Subject: RE: Planning Application for P1704/21/FUL

I confirm the works are for the Erection of an agricultural building with associated works and the building extends to 274sq m.

Gamage Hall. Location Plan

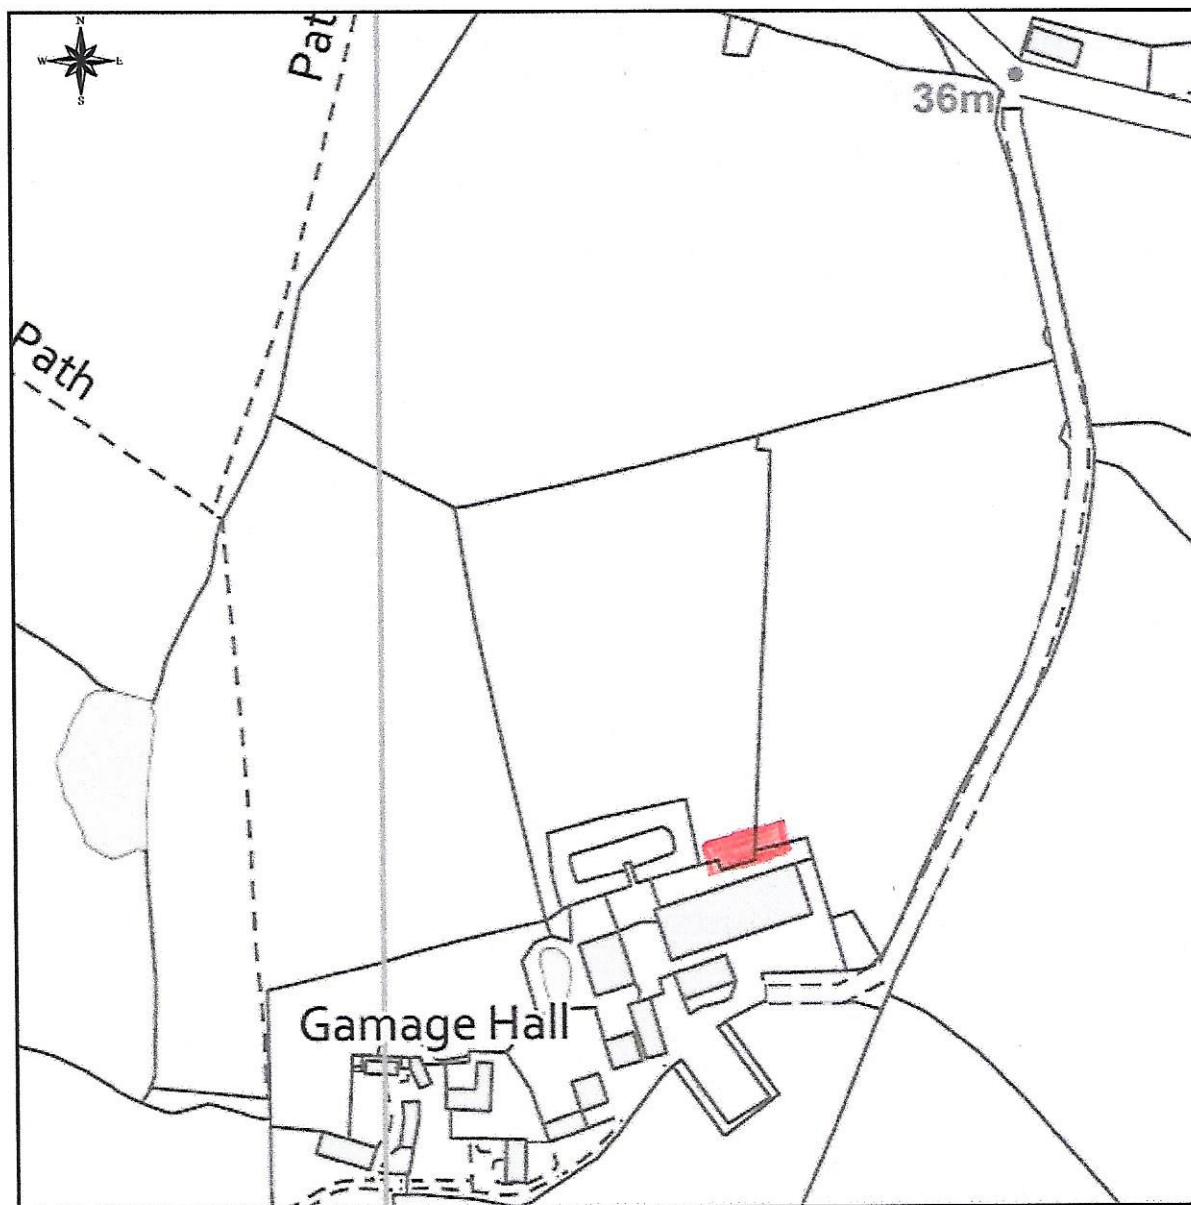
Thank you for your email, the location plan is not to the correct scale, please amend.

The location plan must be either 1:1250 or 1:2500.

Please find 1:2500 location plan attached
